Re: Dunkin Brands
4201 Wyoming Blvd NE
Traffic Circulation Layout
Architect's Stamp 07-06-2020 (G19-D042)

Based upon the information provided in your submittal received 07-16-2020, the above referenced plan cannot be approved for Building Permit until the following comments are addressed:

**2 ONE WAY DETAIL**  
3/4" = 1'-0" NOTE:

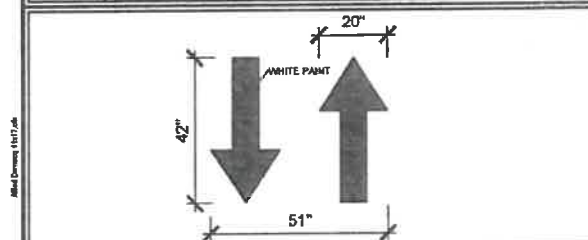
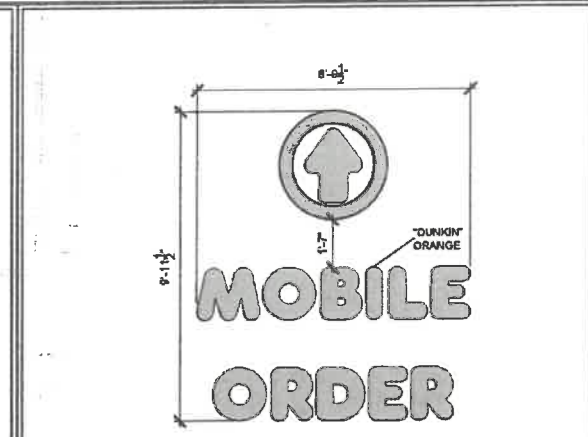
9. All one-way drives shall have "**One Way**" and "**Do Not Enter**" **signage and pavement markings**. This applies to exit entrance on Wyoming Blvd. You need stop signs as well on all proposed entrance that have exit functions.
10. Show all drive aisle widths and radii. Some dimensions are not shown (internal radii's for drive thru striping).
11. Details are needed for any proposed **pavement markings** and/or **signage**.
12. The drive thru center line striping needs color and thickness of striping.

TCL-1.0

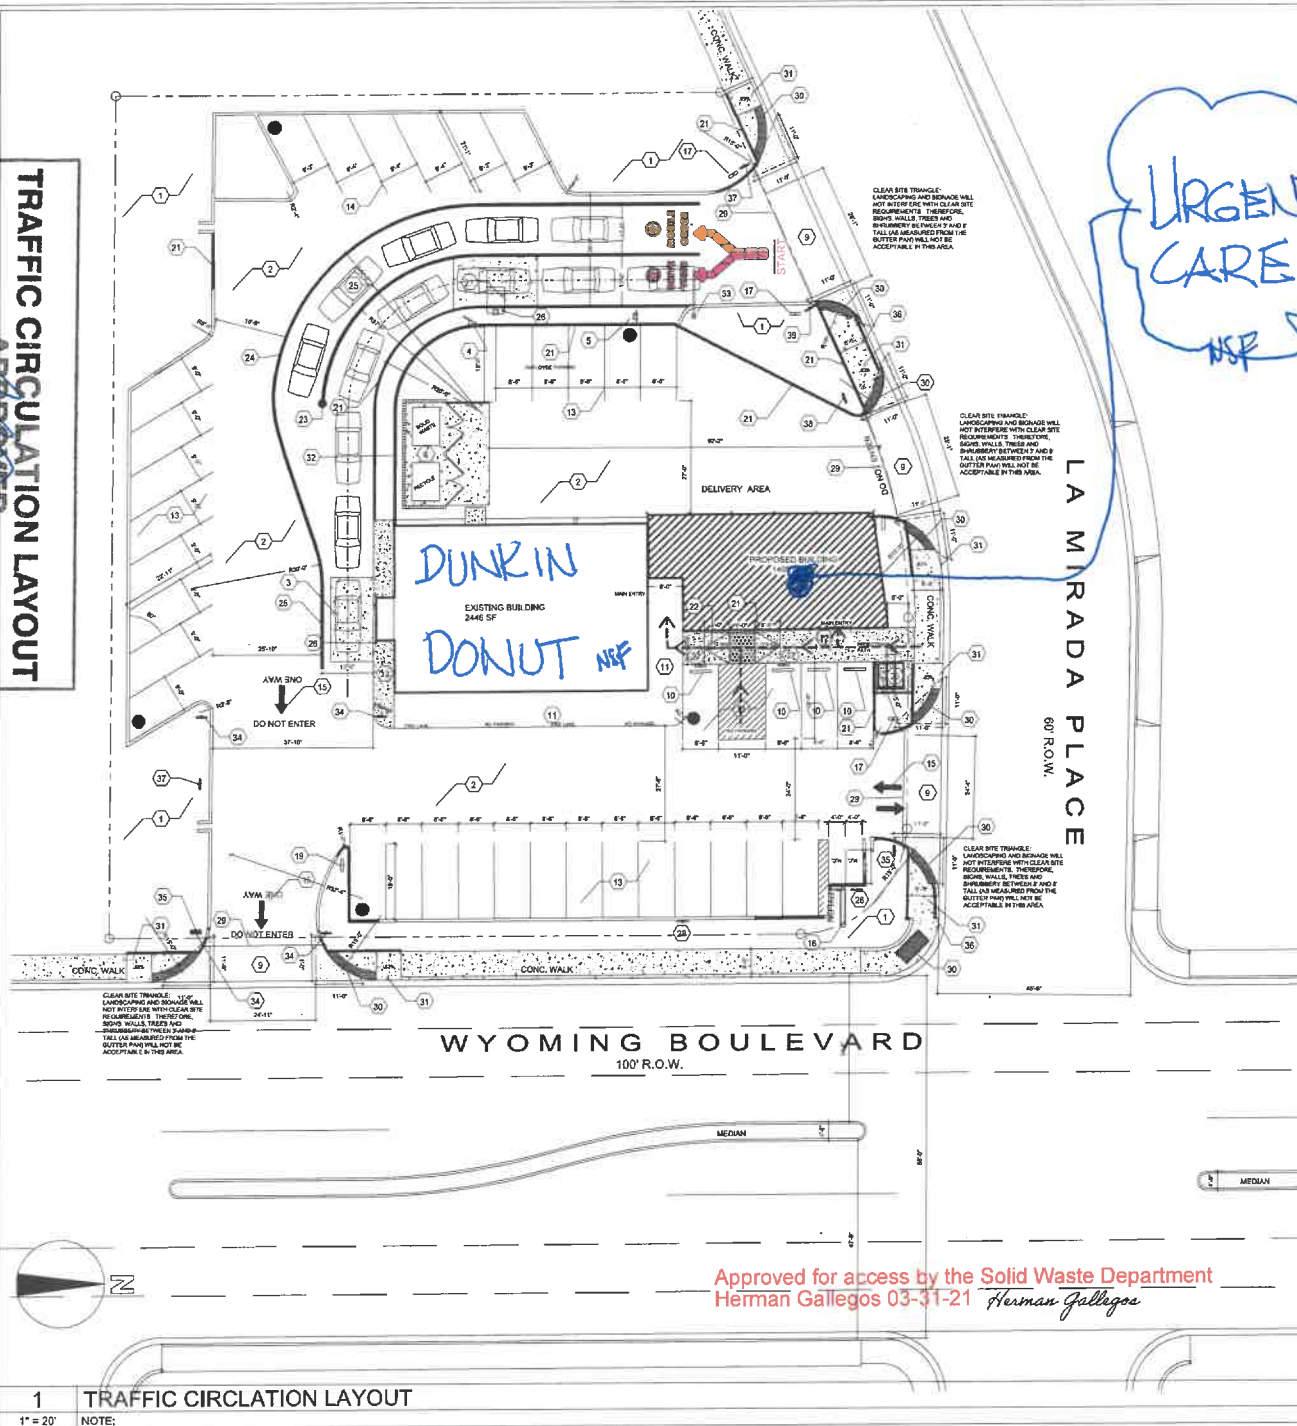
1. ADA curb ramps: The curb ramps from the La Mirada Place driveway ramp and the corner ramp of Wyoming appear to be in conflict as well as the western entrances. Please verify and address this concern and provide detail for the solution. If this is not an issue please advise.

2. Motorcycle parking space: **Label pavement MC.**
3. List radii for all curves shown; for passenger vehicles. **Radius for delivery trucks, fire trucks, etc. is 25 ft. or larger.**

4. Per the IDO, a 6 ft. wide ADA accessible pedestrian pathway is required from the public sidewalk to the building entrances. Please clearly show this pathway and provide details. **Where is this connection from Wyoming? Explain?**

5. Per DPM, a 6 ft. wide ADA accessible pedestrian pathway is required from the ADA parking stall access aisles to the building entrances. Please clearly show this pathway and provide details. **The 6 ft width (LANDING)** includes the ADA ramp. You show 5'-6" on the stalls for the landing but the proposed detail shows 6 ft. Clarify this issue.

6. **All sidewalks along La Mirada Place needs to be dimensioned (width).**
7. **Provide a copy of refuse approval for design and new location.**
8. **DESIGN STANDARDS(for entrance needs to be 2426 not 2425): Dwg 2426 but the 6 ft valley gutter needs to be called and with 1 inch invert (1" invert) instead of 1-1/2 inche invert.**
